Reference AL/107/16/RES

I object to the above named application for the following reasons:-

Drawing Title:-
**STREET LIGHTING
LAYOUT**

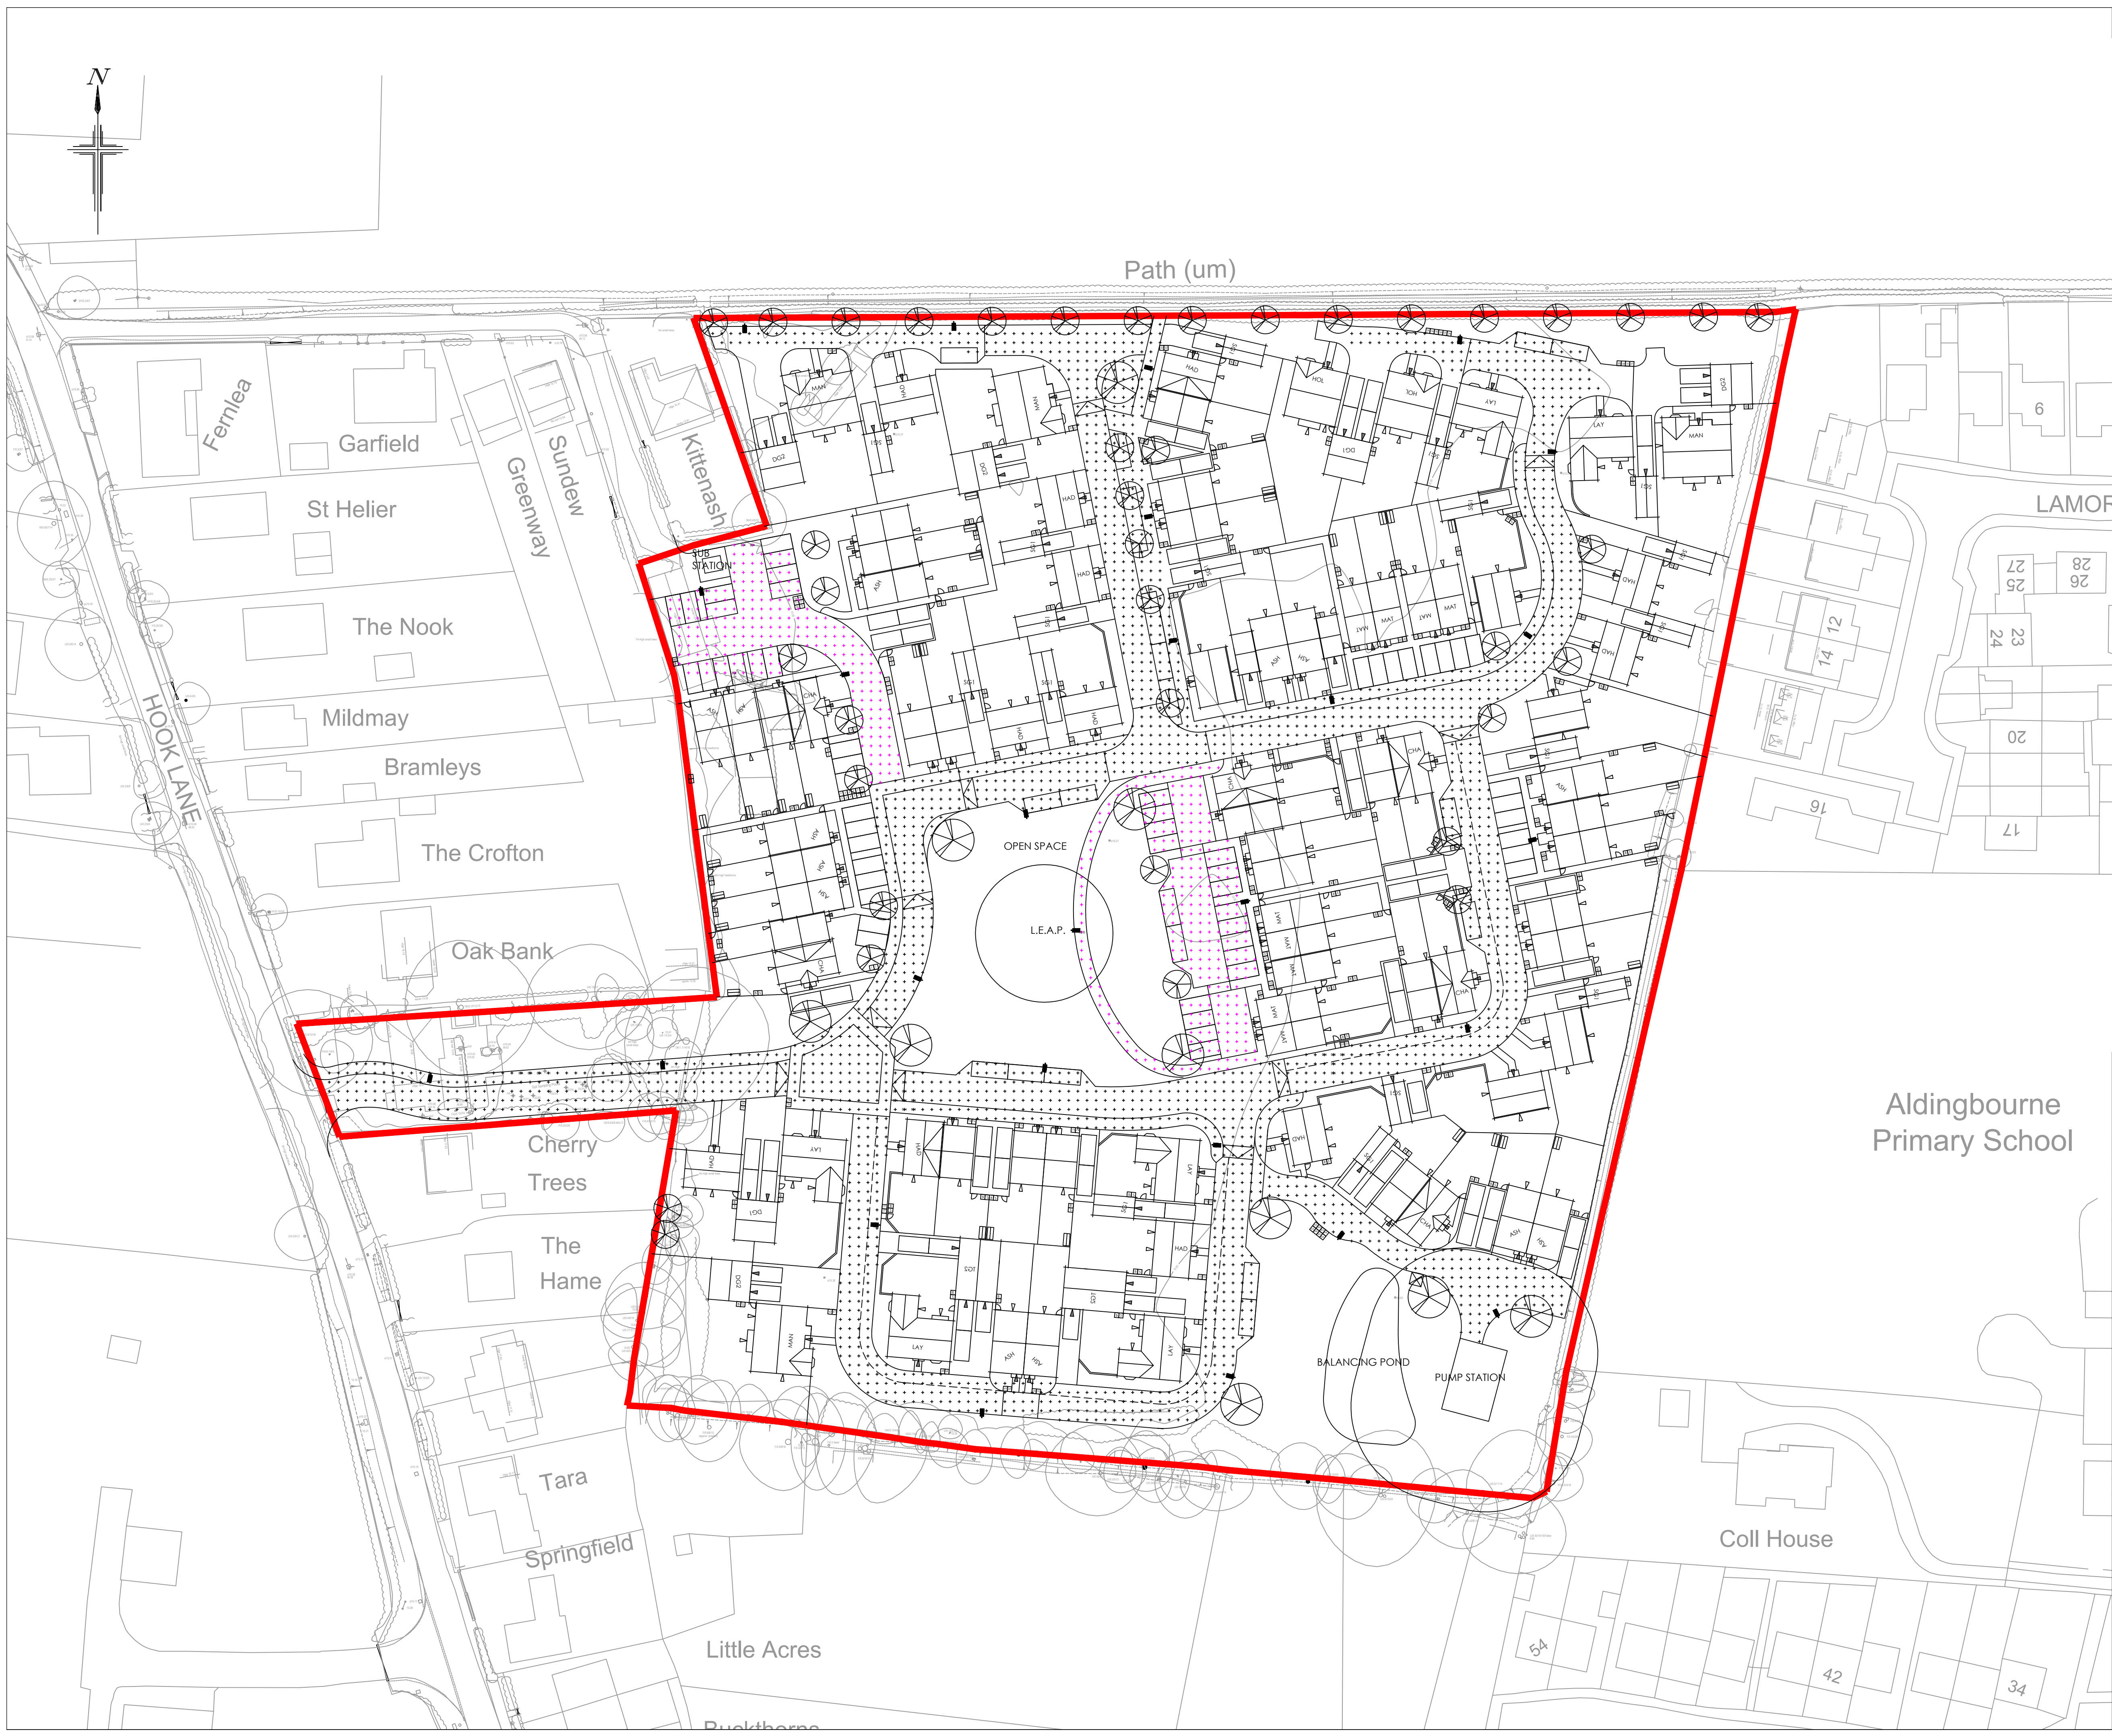
1. The scale density & layout of the application will greatly increase the risk of flooding to existing properties. I have personal knowledge of the local water table & experienced it when main drainage was installed. As soon as digging commenced the water was at ground level. Far fewer houses would reduce the risk of flooding of sewage & surface water. The existing fields acted as flood plains.
2. The large number of houses proposed would change drastically, the nature of what is a narrow country lane (See ANDP Policy H3.1 & NPPF6.)
3. The Aldingbourne Neighbourhood Plan's policy of maintaining Dark Skies would be badly affected by the introduction of Street Lighting. Natural darkness would be destroyed & disrupt night species such as Tawny owls & bats. Extreme limits should be put on new lighting. (Policy EH 10/13.1.)
